From: [REDACTED]
Sent: 26 February 2026 11:46
To: Susan Haley
Cc: Laurence Hall
Subject: Re: P/3/26/HH – Commonmead Barn, Pagham Road
Attachments: 846-PL100B - As Proposed Site Location Plans RevB.pdf; 846-PL101A - As Proposed Site Plan RevA.pdf; 846-PL102A - As Proposed Ground Floor Plan RevA.pdf; 846-PL103A - As Proposed Roof Plan RevA.pdf; 846-PL105A - As Proposed Extension Elevations RevA.pdf; 846-SU100A - As Existing Site Location Plans RevA.pdf; 846-SU101A - As Existing Site Plan RevA.pdf

I have begun reviewing application P/3/26/HH – Commonmead Barn, Pagham Road and have noted that the detached garage is not located on the proposed site block or location plans. Please see below as marked in yellow.

Drawing Title:
As Proposed
Site Location Plans

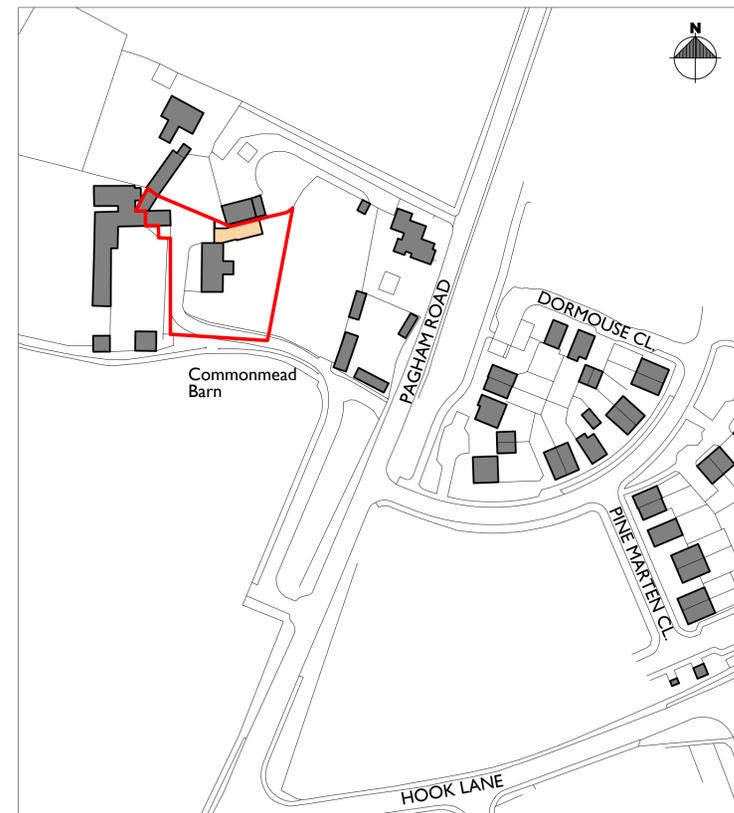
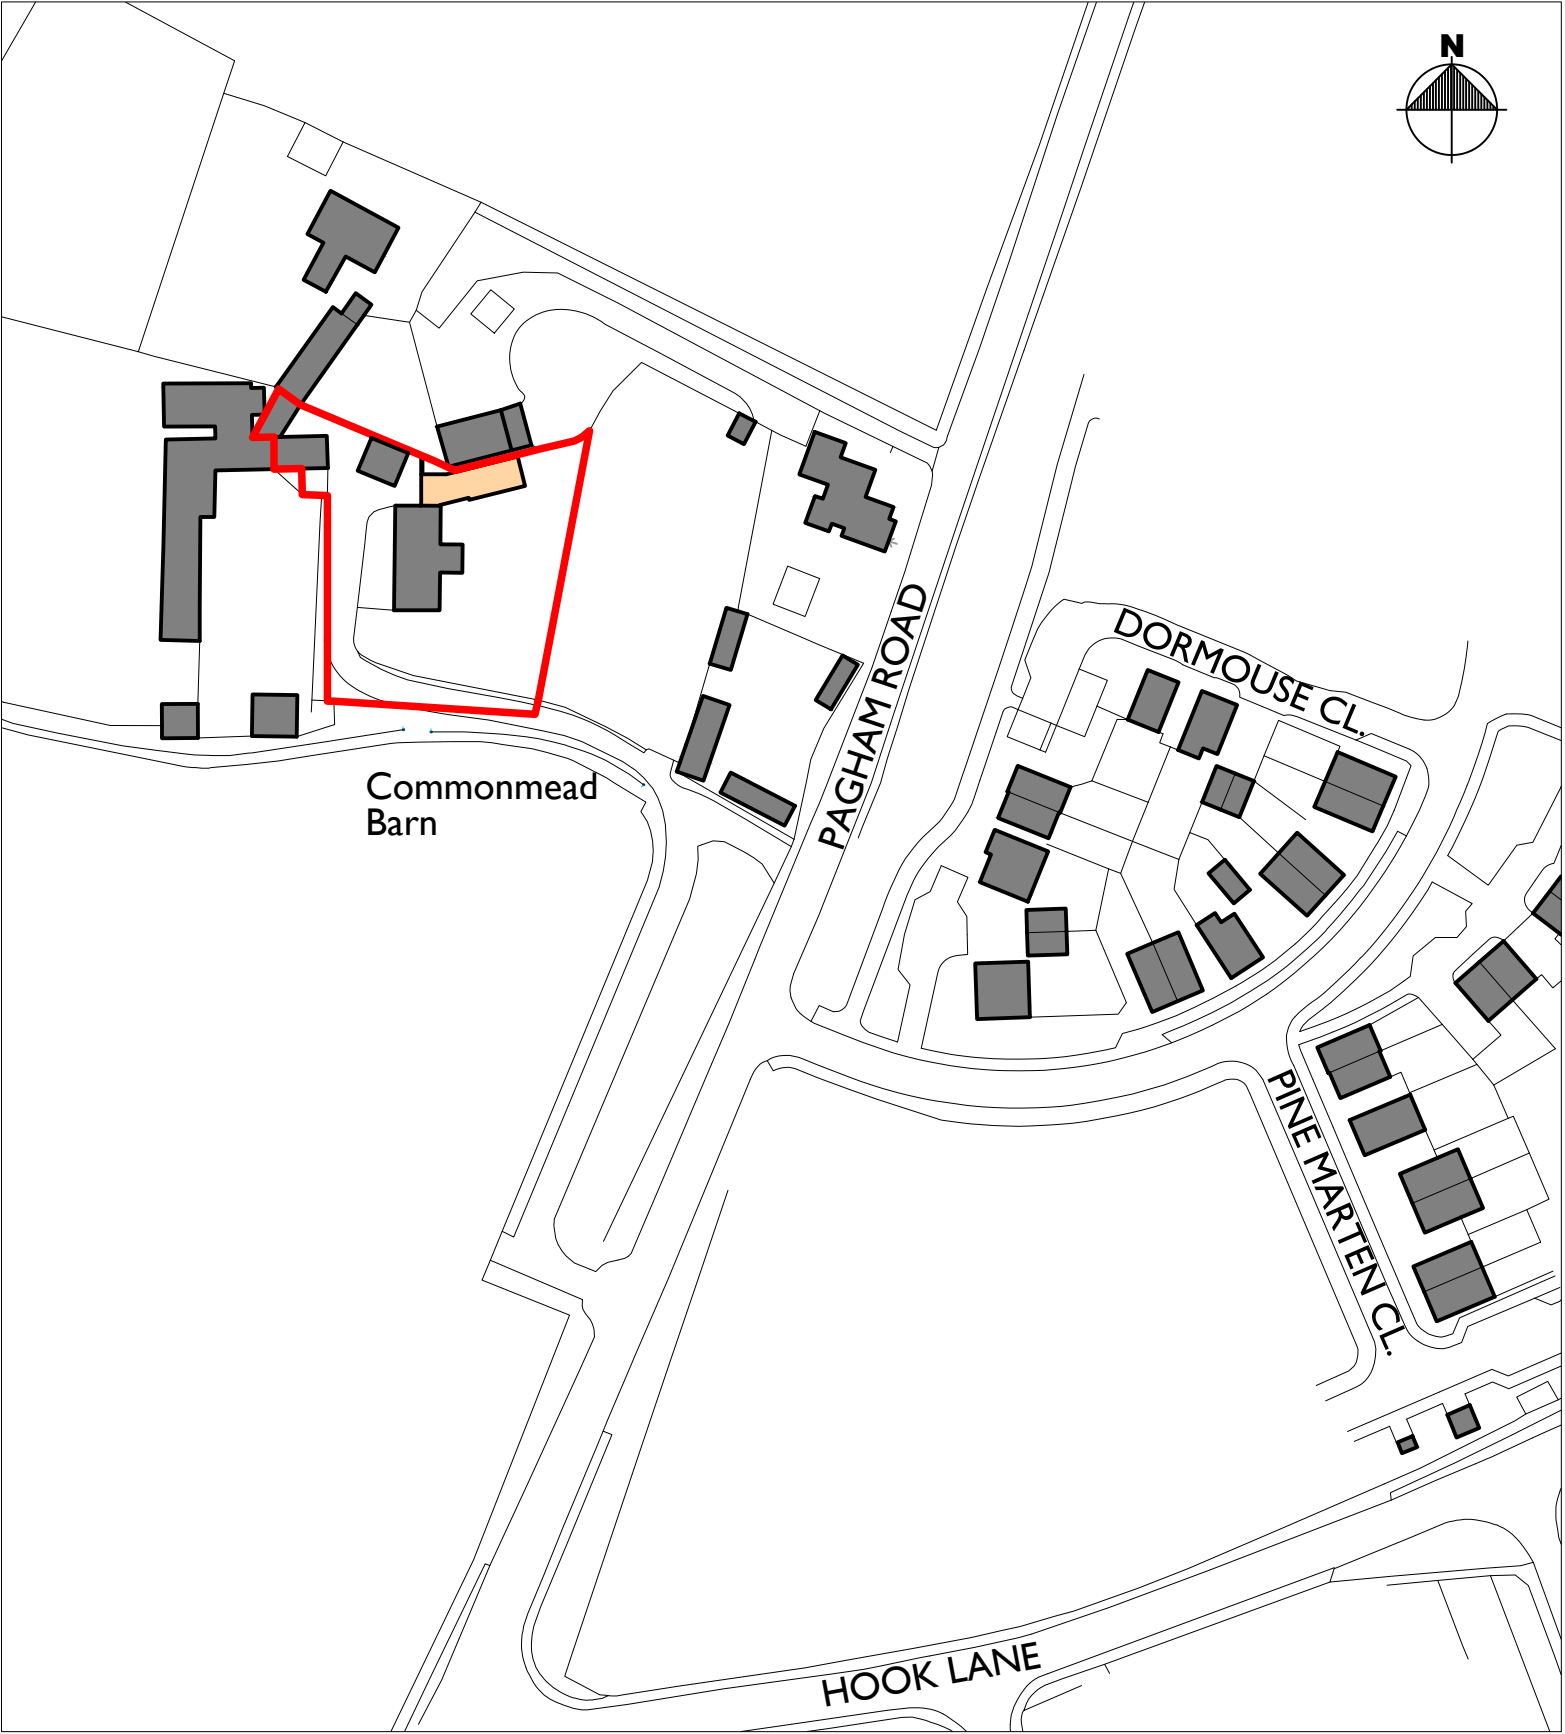
Proposed Site Block Plan

Proposed Site Location Plan

Please can you amend the plans accordingly and email me an updated copy no later than 5 March 2026.

Thank you for your email, please see the attached revised drawings amended to show the existing double garage.
